From: Erin Moore
Sent: Tuesday, June 18, 2013 10:44 AM
To: Jeff Watson
Subject: FW: BL-13-00008 Orr

From: Jeff Watson
Sent: Wednesday, June 12, 2013 12:49 PM
To: Christina Wollman; Brenda Larsen; Jan Ollivier; Holly Duncan
Subject: BL-13-00008 Orr

[BL-13-00008 Orr](#)

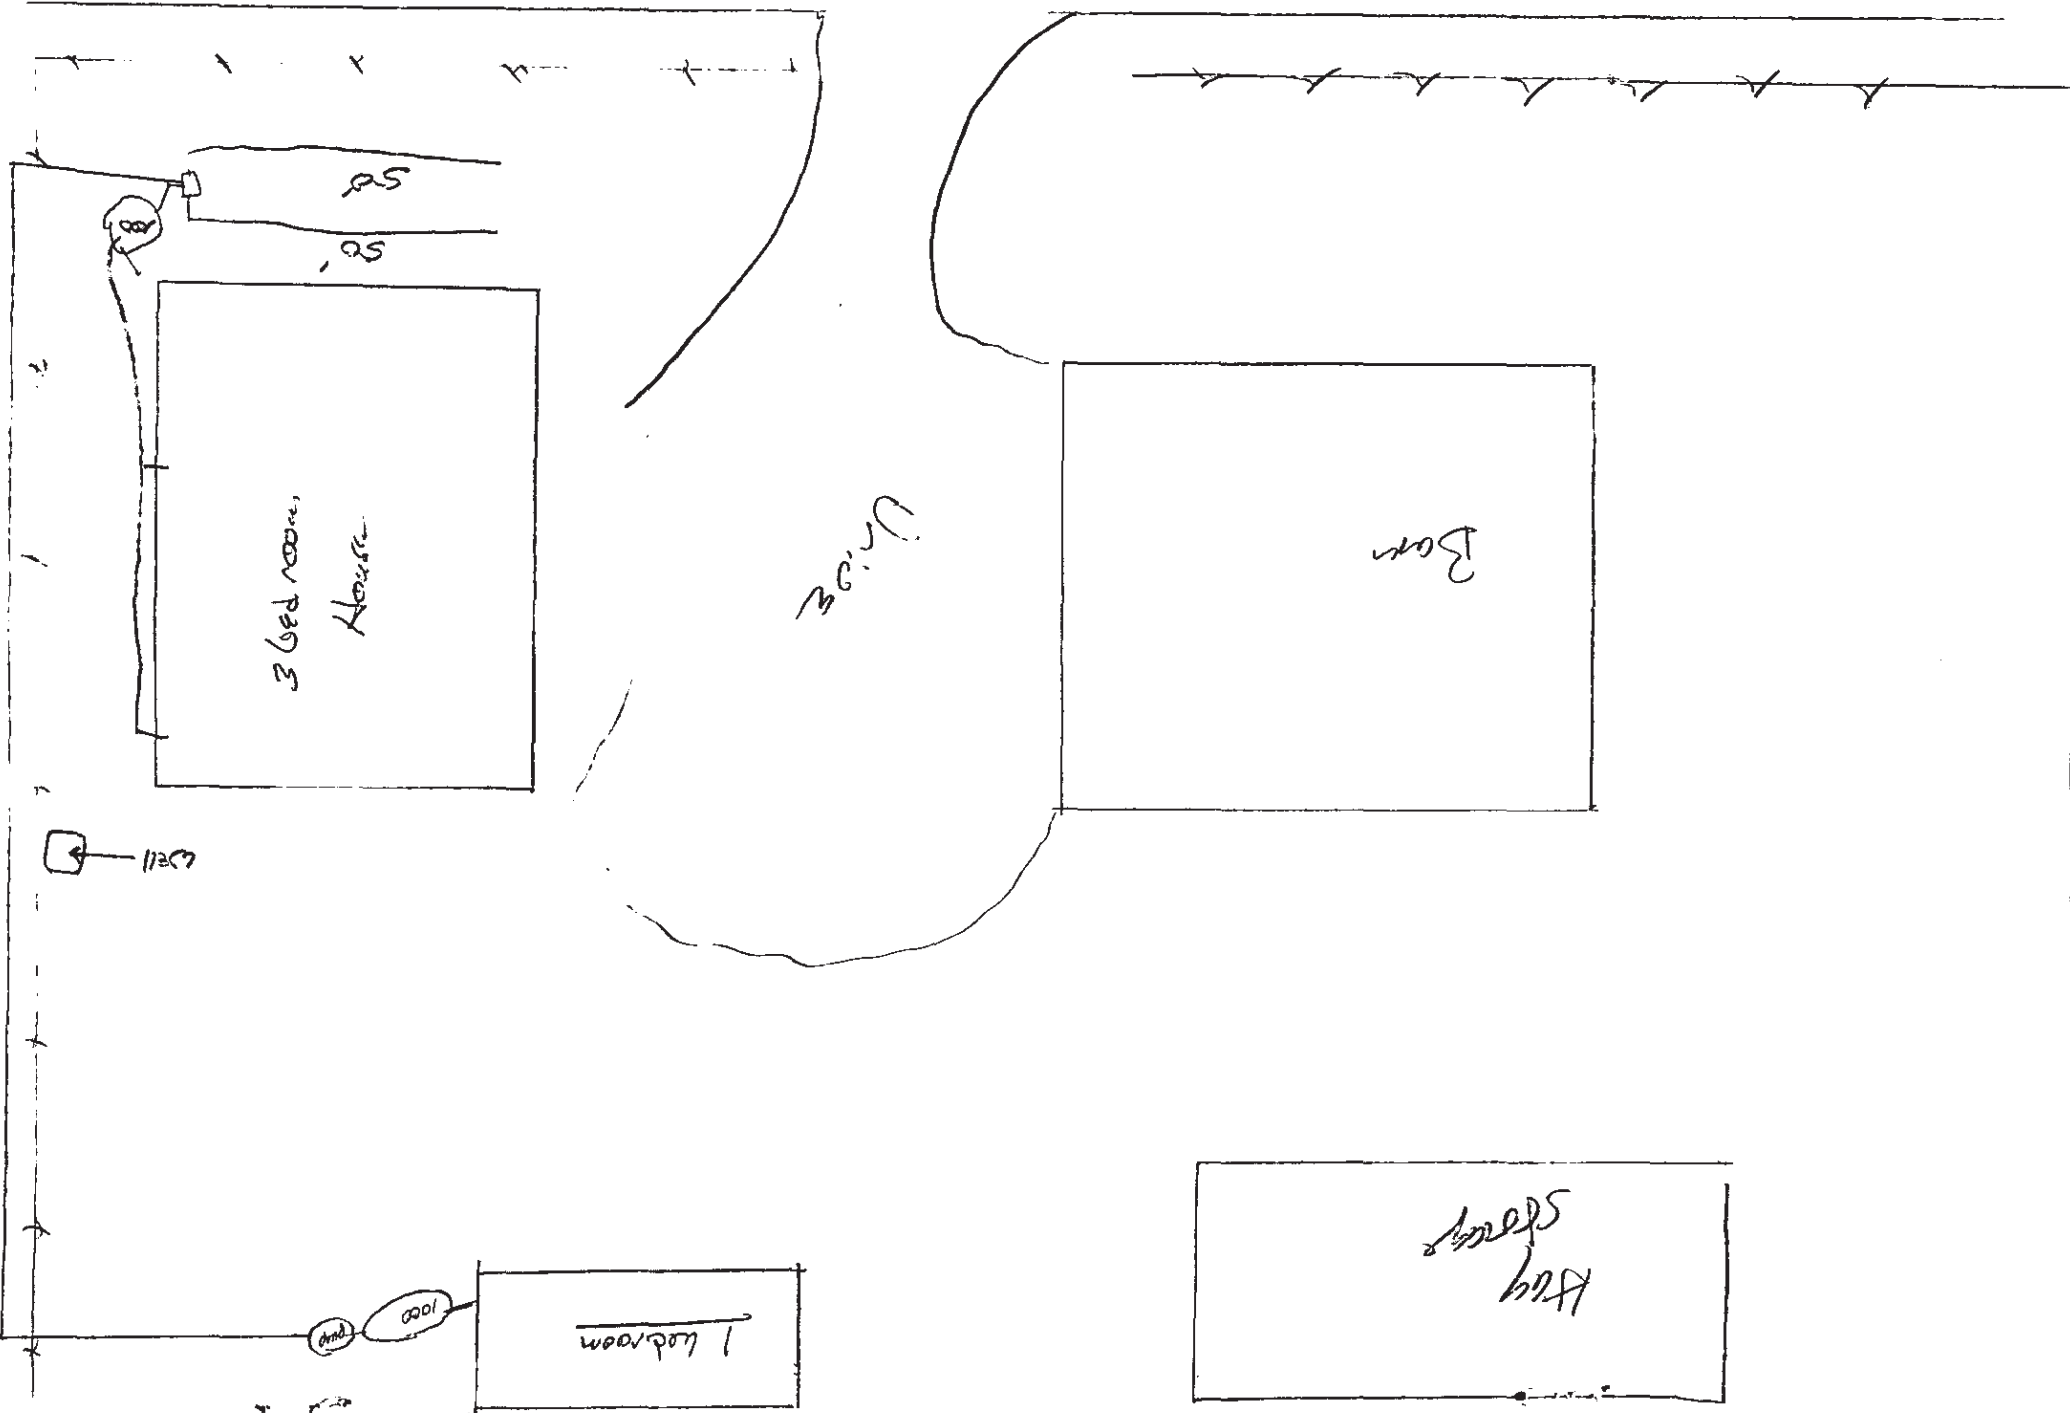
This one should be OK for the well location. The proposed lot line doesn't appear to be close to where the well is on the 5 acre parcel.
